Our Ref: H/2/12/L

23rd February 2012

**Application for Listed Building Consent for various internal alterations & renovation of existing hardwood, double-glazed conservatory (this application lies within the South Downs National Park Authority)
2 St Nicholas Cottages The Street Houghton**

2 St Nicholas Cottages
Proposed floor plan 2012
Scale 1:50
Ref: H/2/12/L
Renovation + alteration
Mr and Mrs. S Smith

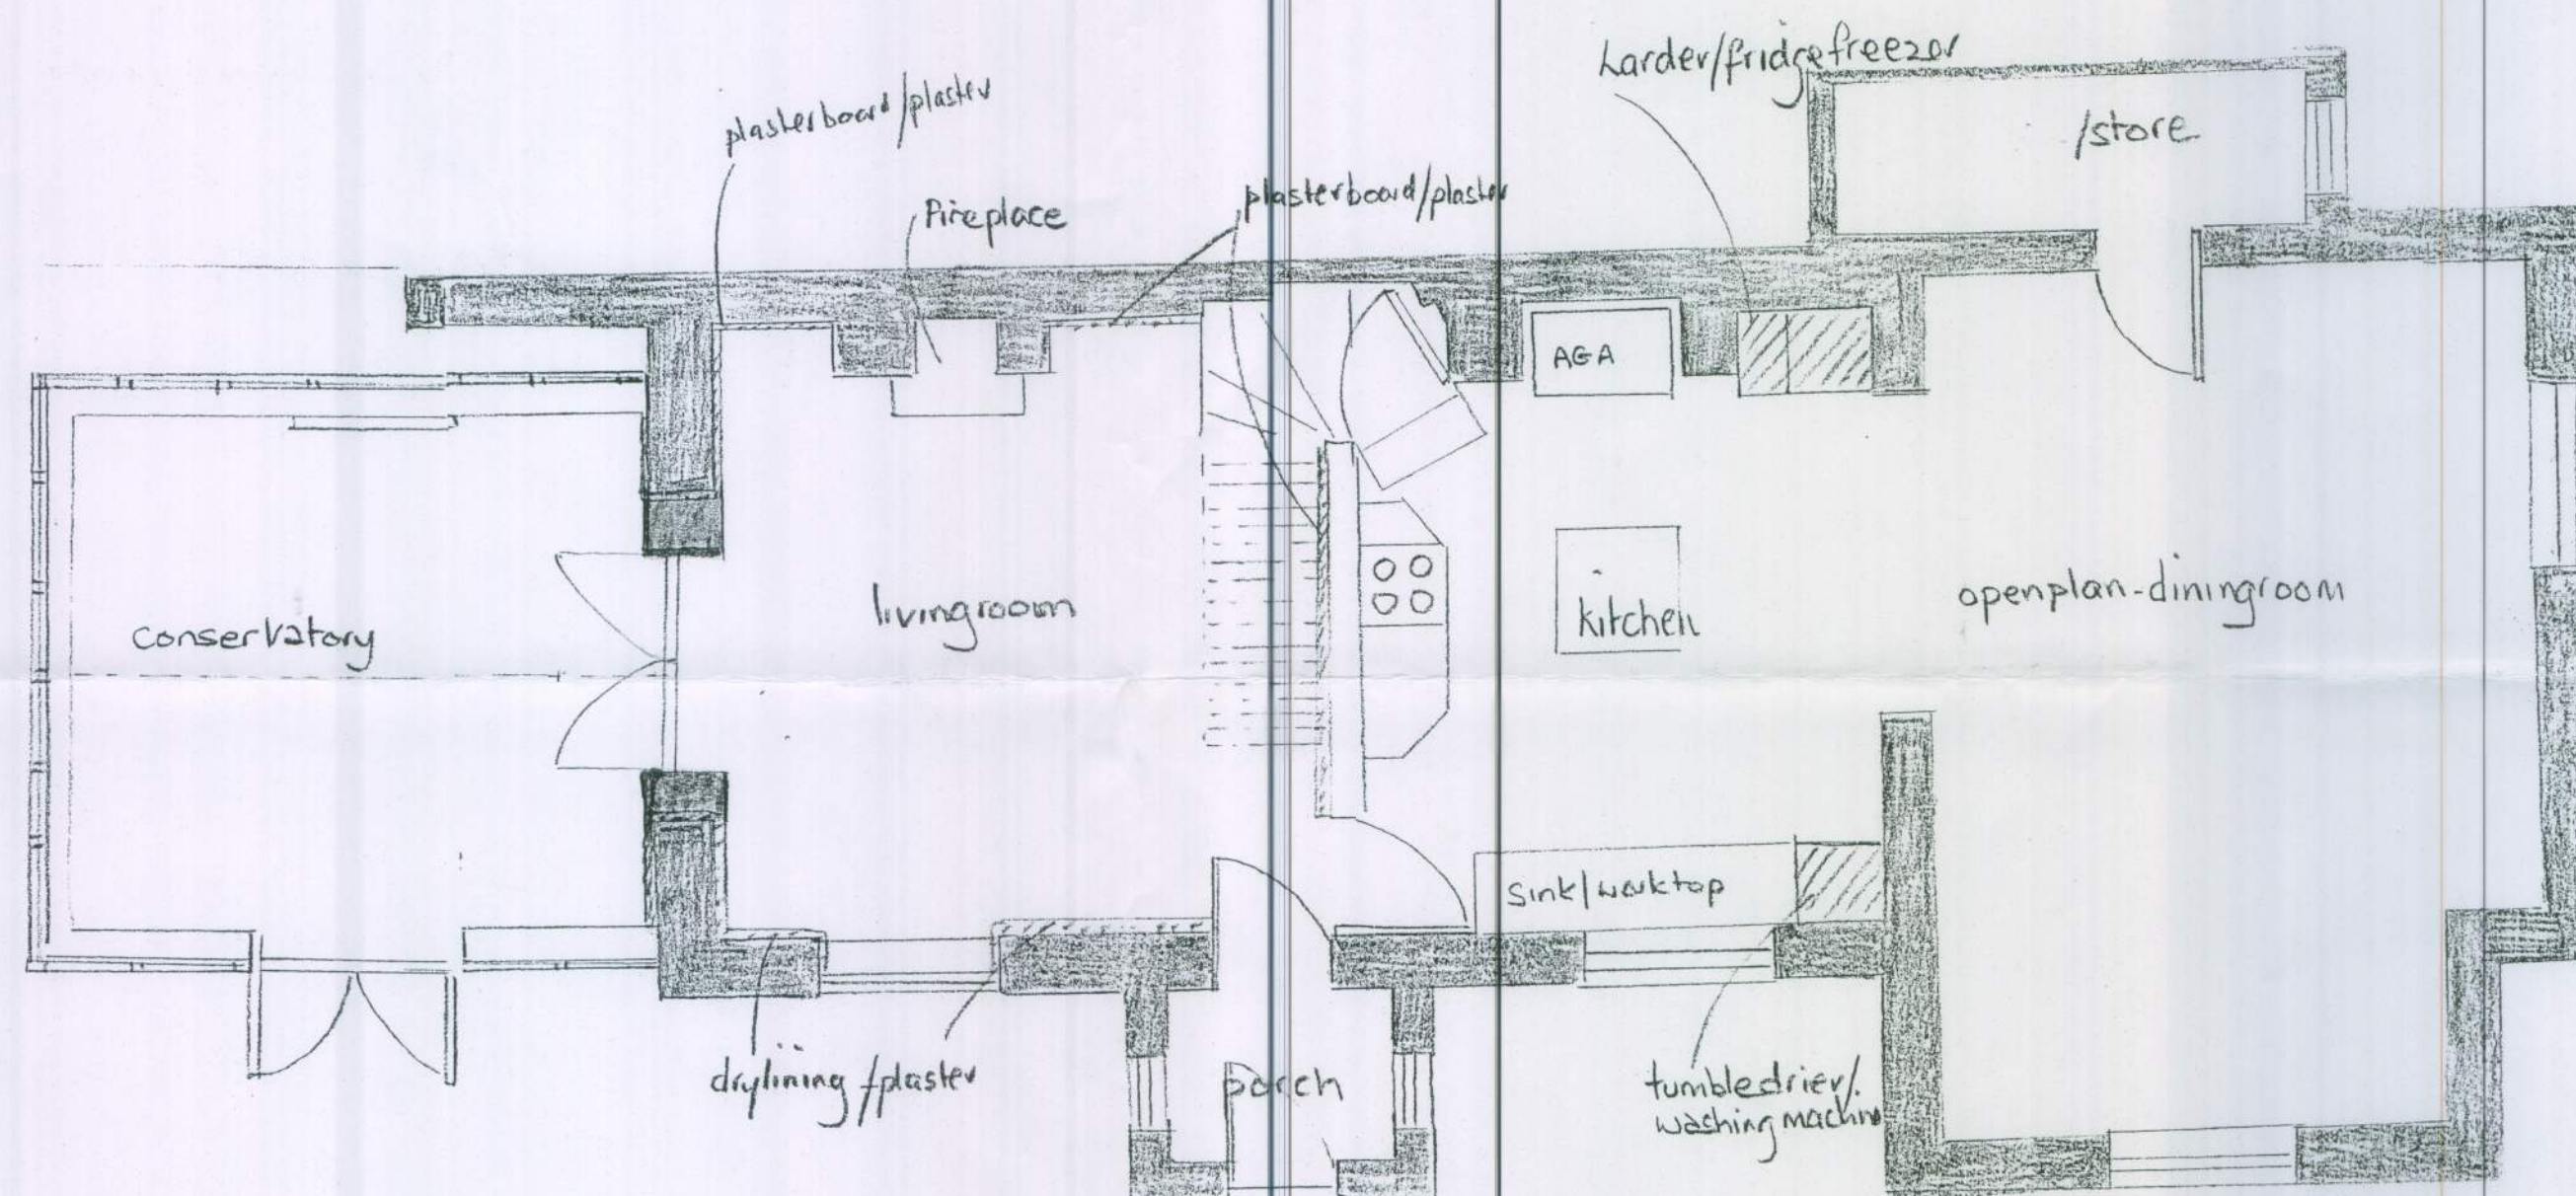
I therefore request that this element of your proposal is deleted from the application. If it remains part of the application then I would advise that it is likely the application will be refused in relation to the adverse impact of this part of your proposal on the Listed Building.

Without prejudice, I would appreciate confirmation of your client's intentions and amended floor/elevation plans within 10 days of the date of this e-mail. If no response is received the application will be determined as submitted.

I would like to confirm that my client has withdrawn the application to widen the existing doorway from the lounge to conservatory at No1 St Nicholas Cottages and I attach an amended floor plan (showing the area relating to this part of the application only) showing the existing opening as examined by the Historic Buildings inspector and confirm that the existing structural width and height of the opening will not be changed.
